CITY OF ALBUQUERQUE

May 19, 2022

Re: Stripes Burrito Co.
2781 57th St. NW
Traffic Circulation Layout
Architect's Stamp 04-18-22 (H11-D073)

1 Site Plan-  
Scale: 1" = 20'-0"

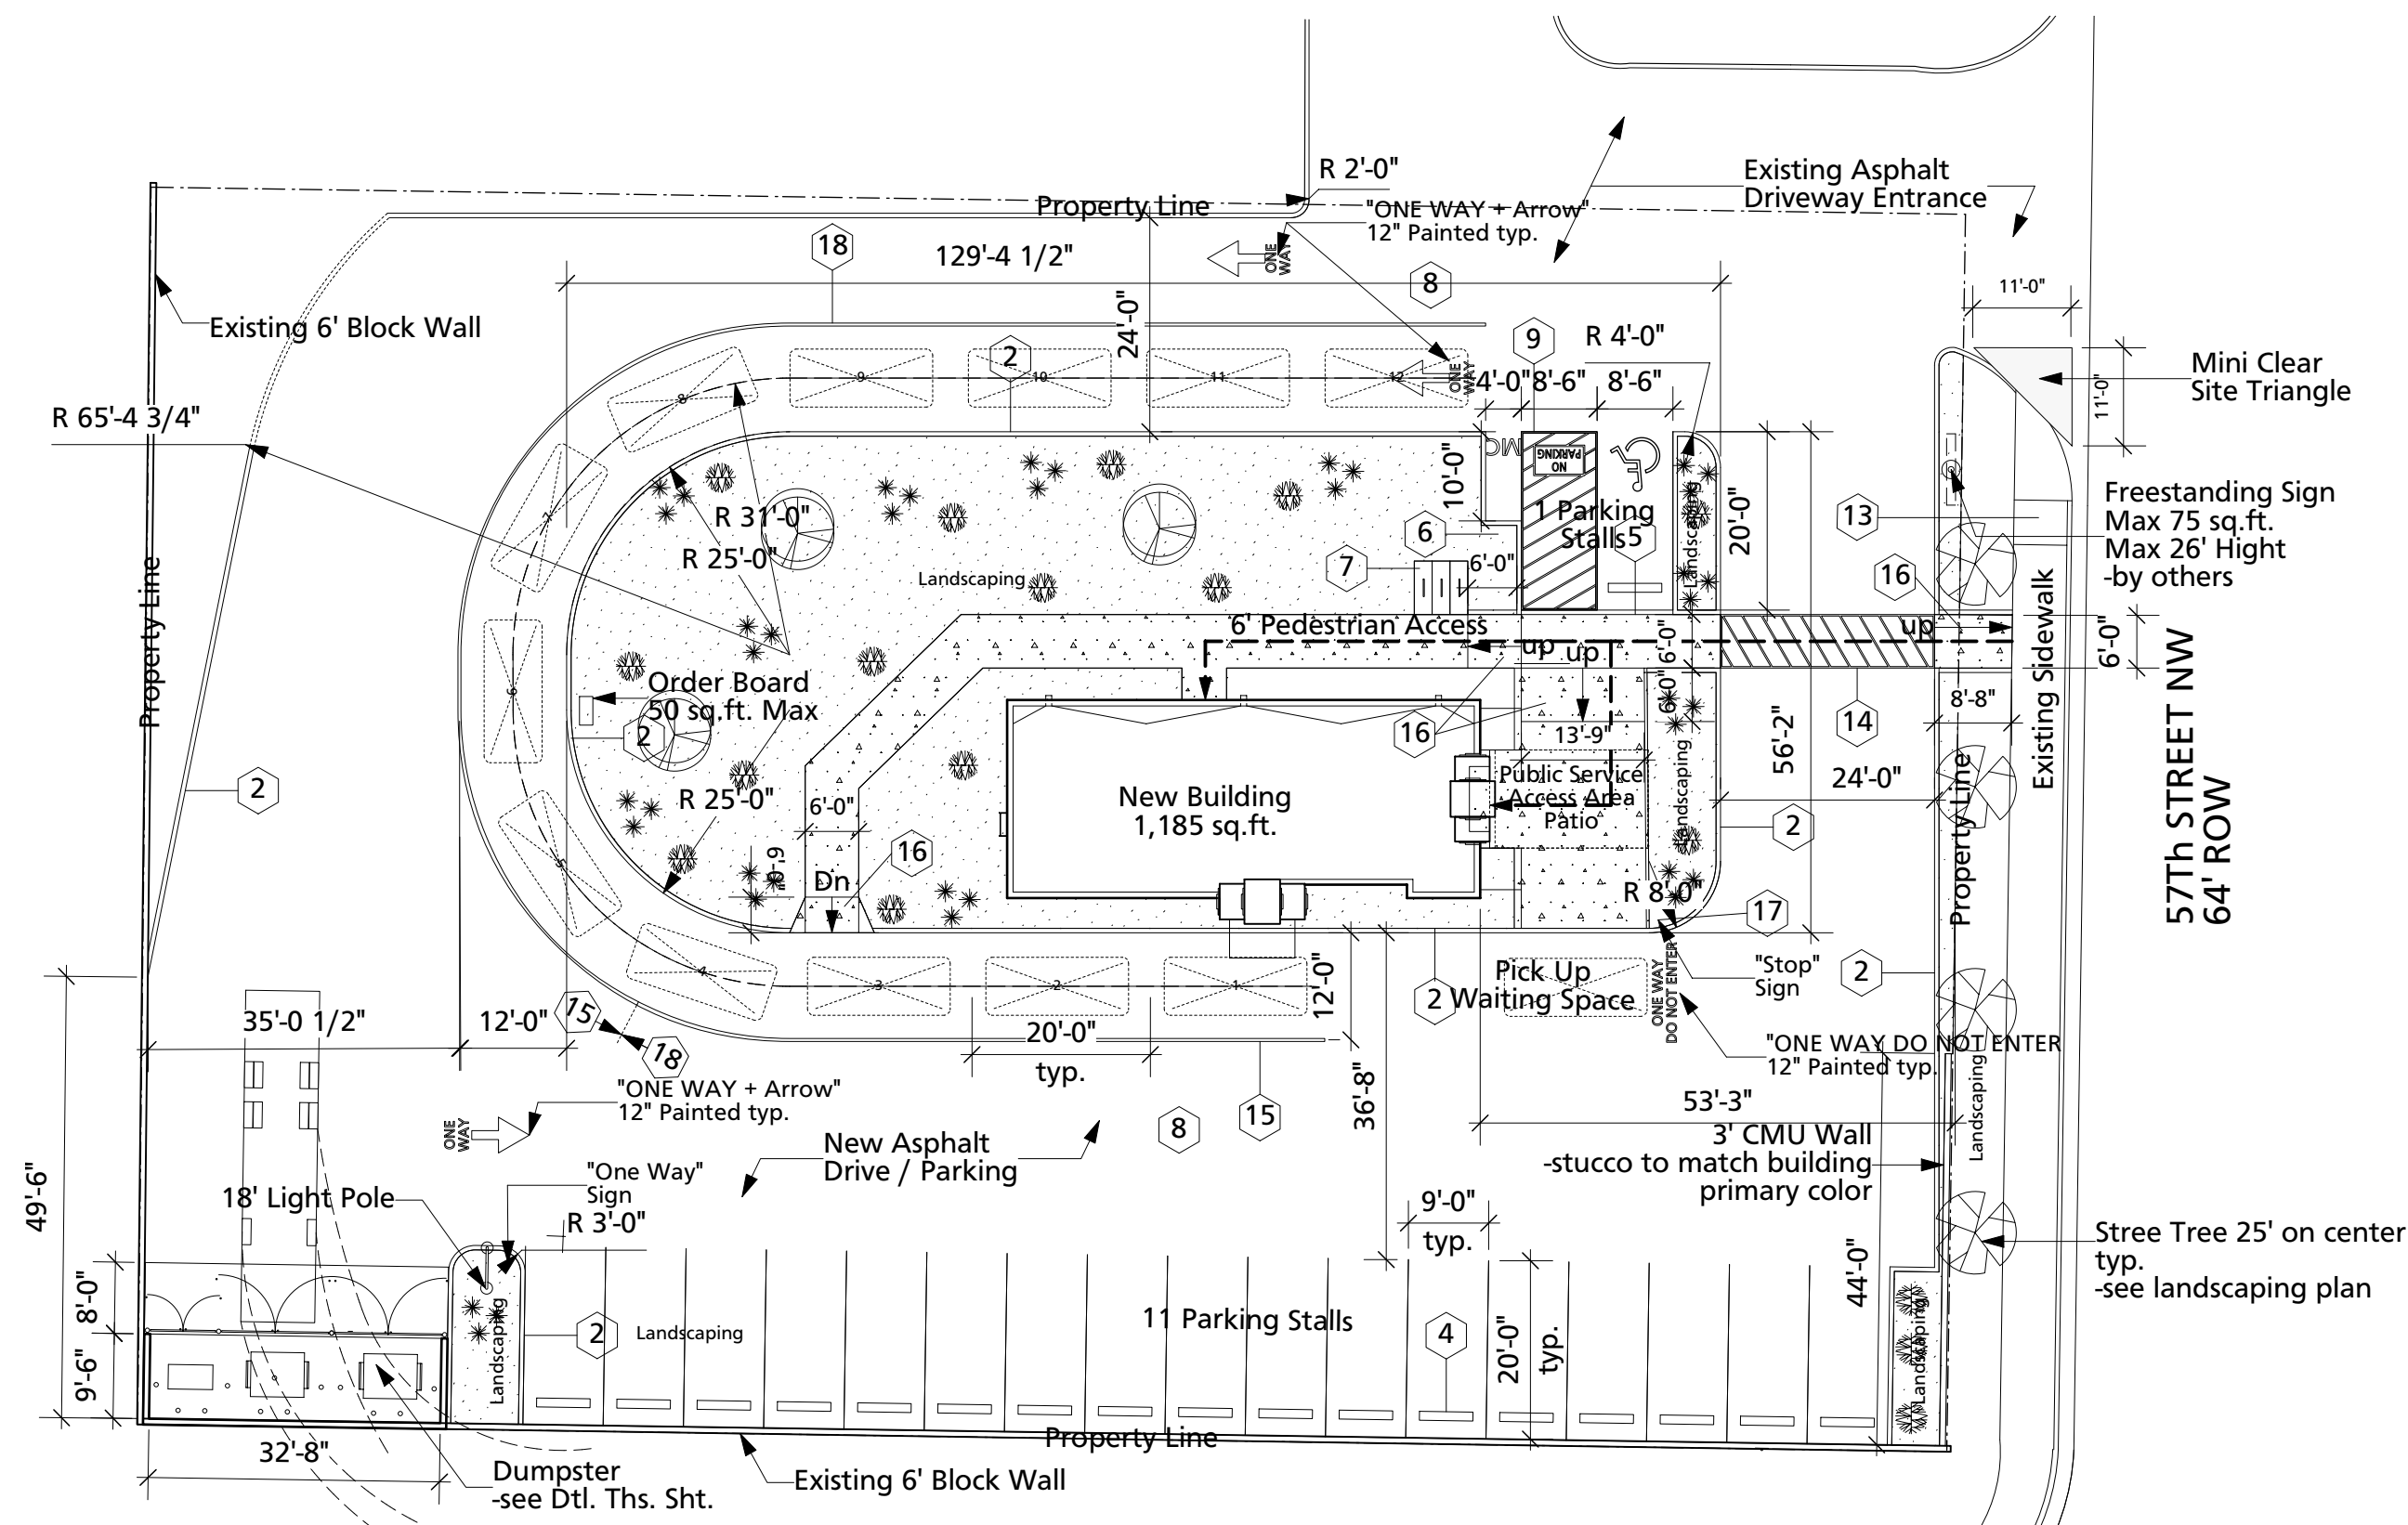
1. Provide a queuing calculations to ensure it doesn't back into the entrance and 57th Street. For more information please contact Jeanne Wolfenbarger at (505-924-3991)

2. All one-way drives shall have "One Way" and "Do Not Enter" signage and pavement markings. Please **show detail and location of posted signs and striping**.

3. Paint the drive-thru strip white when it separates the same direction drive aisles (at the north side of the building), and paint it Yellow when it separates different direction drive aisles.

4. ADA curb ramps must be updated to current standards and have truncated domes installed.
5. Motorcycle parking spaces shall be designated by its own conspicuously posted upright sign, either free-standing or wall mounted per the zoning code.

6. The pavement marking "MC" should be shown in the opposite direction for motorcycles entering the parking space.
7. Define ADA pedestrian pathway from the public sidewalk and from the ADA parking aisle to the building entrance by labeling the ramps, flush pavement, provide details for each internal ramp, and reference COA std. dwg.

8. Please specify the City Standard Drawing Number when applicable.
9. Please provide a letter of response for all comments given.
